KITTITAS COUNTY

MEMORANDUM

TO: All Staff
FROM: Public Works Plan Review Team
DATE: November 2th, 2022
SUBJECT: BL-22-00009 Palomino Fields Div 8 Lot 6

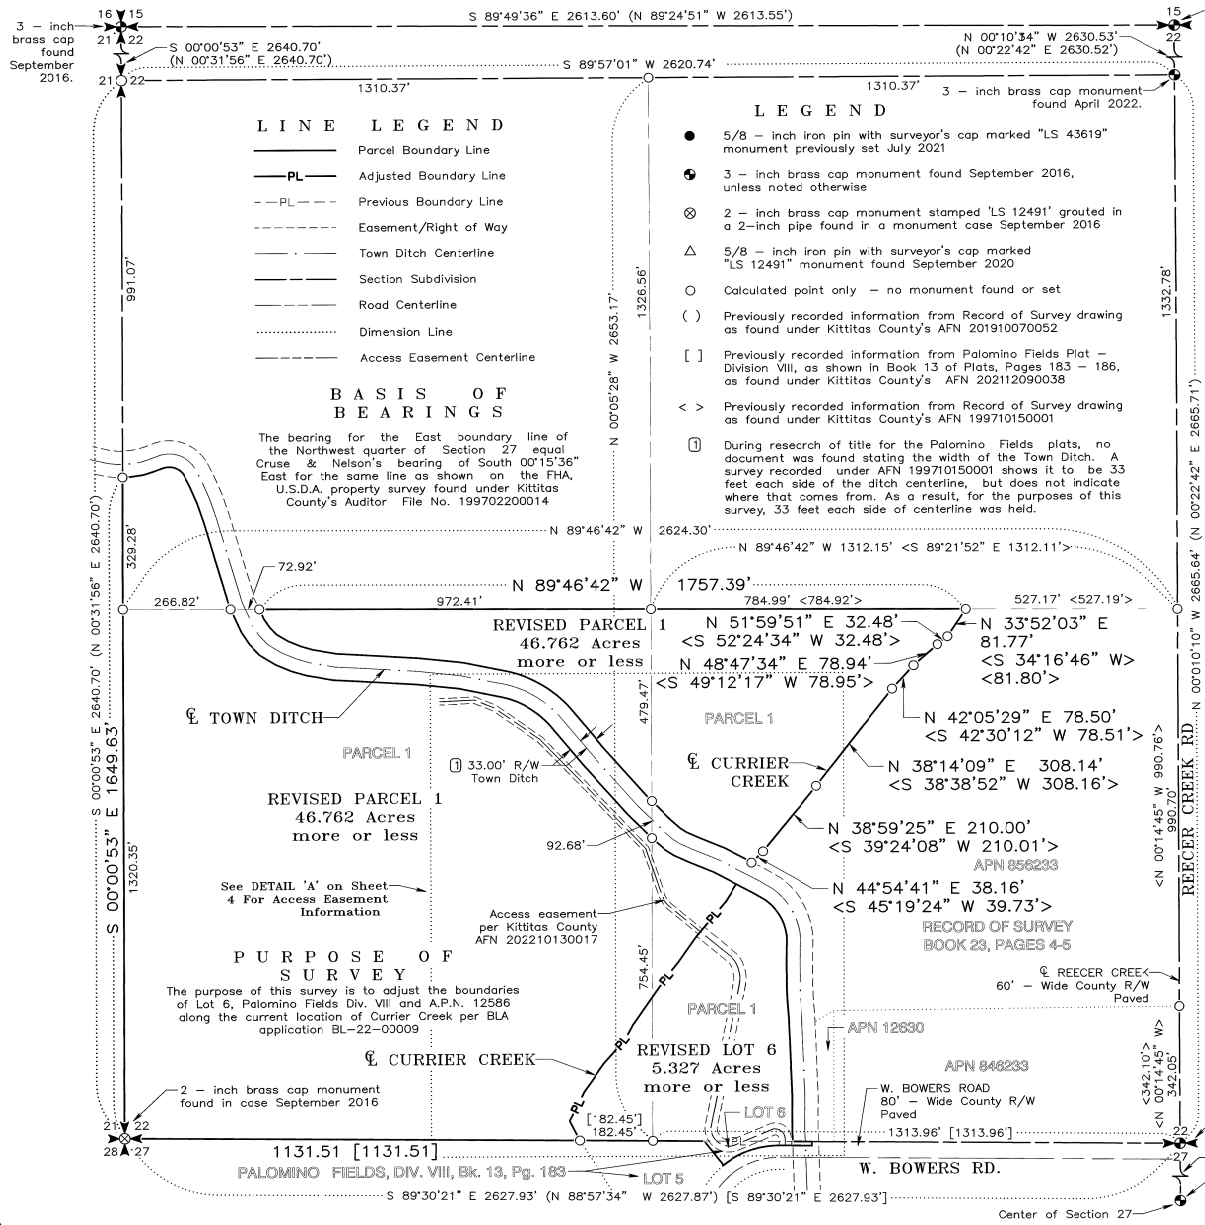
not guaranteed to any existing or created parcel on this application
ENGINEERING	
SURVEY	<ol style="list-style-type: none"> 1. Please include a "Purpose of Survey Statement" (EX: The purpose of this survey is to delineate property boundaries for Kittitas County Boundary Line Adjustment Application No. BL-22-00009.) or something similar. 2. Please show the building located on Revised Lot 6. (Needed for Prelim, not required for final) 3. Please show label for adjacent Survey Bk:23, Pg:4. 4. Please show R/W width, ownership and surfacing for Roan Dr., W. Bowers Rd., and Reecer Crk. Rd. (EX: Reecer Crk. Rd. 60' County R/W - Paved)
FLOOD & WATER MITIGATION/METERING	No further comments
